RESPONSE TO SUBMISSIONS: WOOLWORTHS WAREHOUSE AND DISTRIBUTION CENTRE AUBURN MODIFICATION 1 (SSD-10470-MOD-1)

11 AND 13 PERCY STREET, AUBURN
LOT 1 AND 2 DP1183821

3 February 2022

SSD-10470-MOD-1

Drawing Title:
Ground Floor Plan

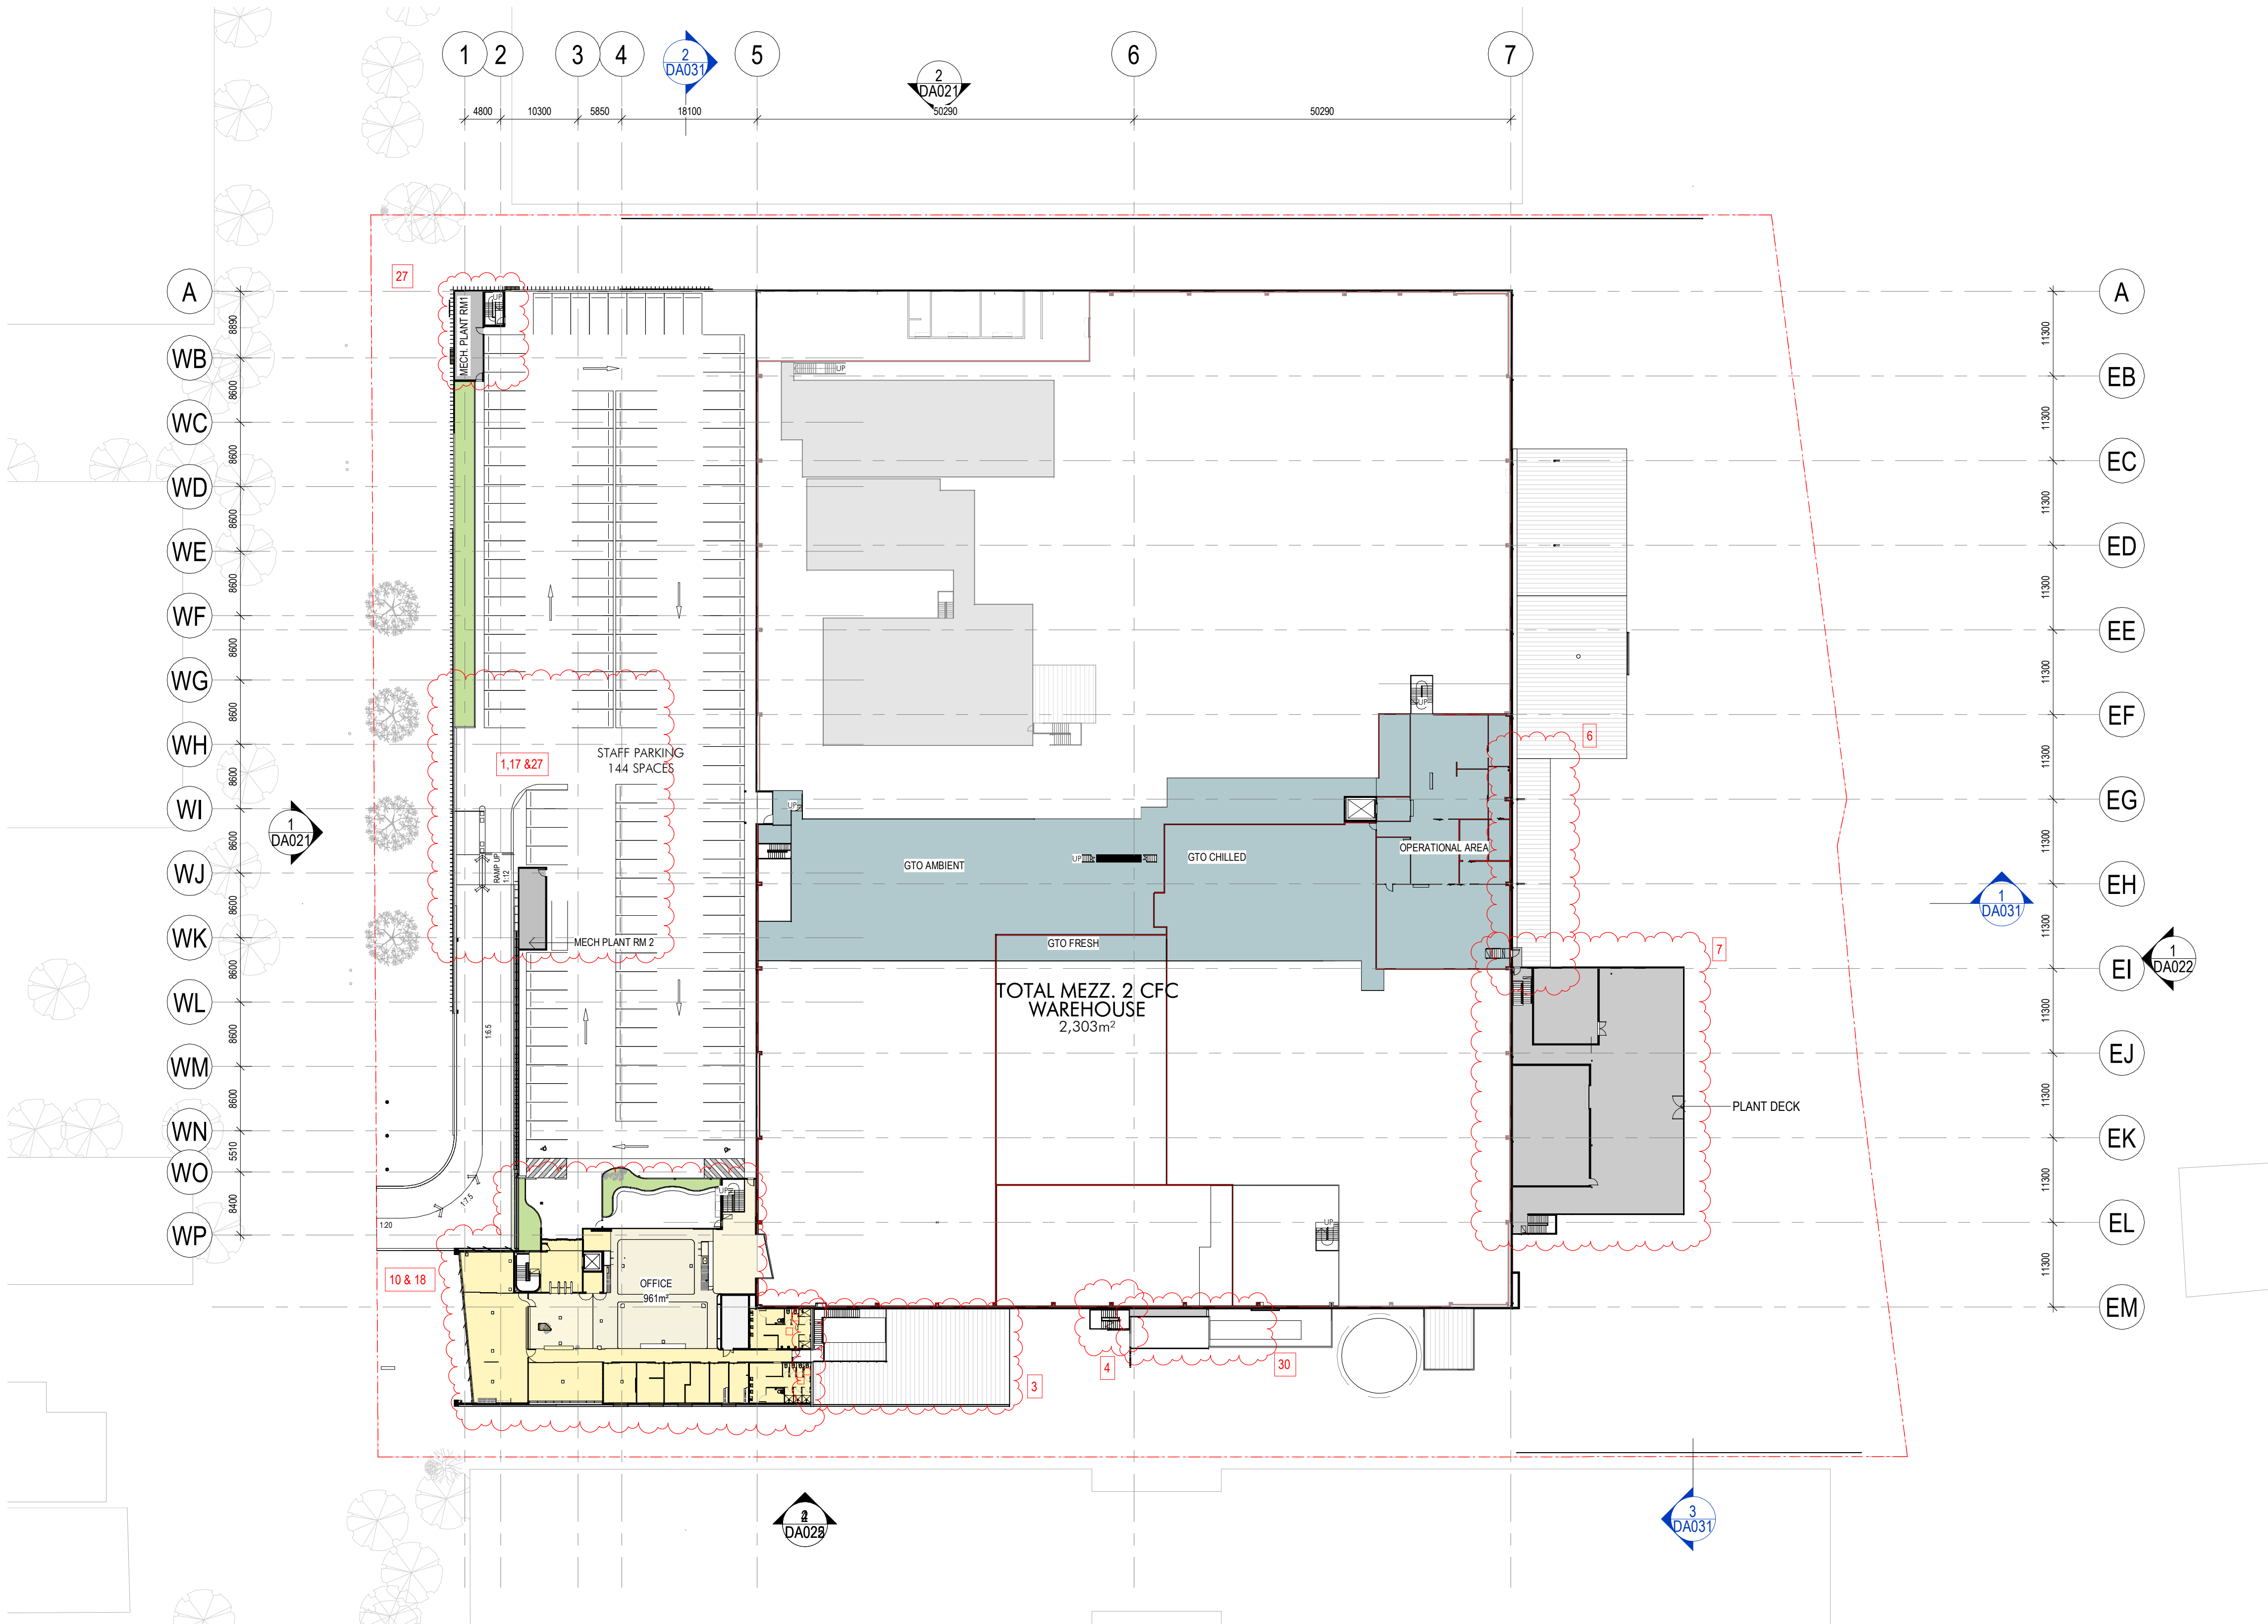
TABLE 1: RESPONSE TO AGENCY SUBMISSIONS			
SUBMITTER	MATTERS RAISED	COMMENTS / REQUESTS	FORMAL RESPONSE
NSW DPE	General	Please provide clarification on the location of the additional diesel tank (item 12 of table 4), and the additional maintenance and wash bays (item 14 of table 4).	The location of the additional diesel tank and maintenance and wash bays are highlighted in FIGURE 1 below.  FIGURE 1. LOCATION OF PROPOSED DIESEL TANK AND MAINTENANCE AND WASH BAYS (SOURCE: NETTLETON TRIBE, 2022)
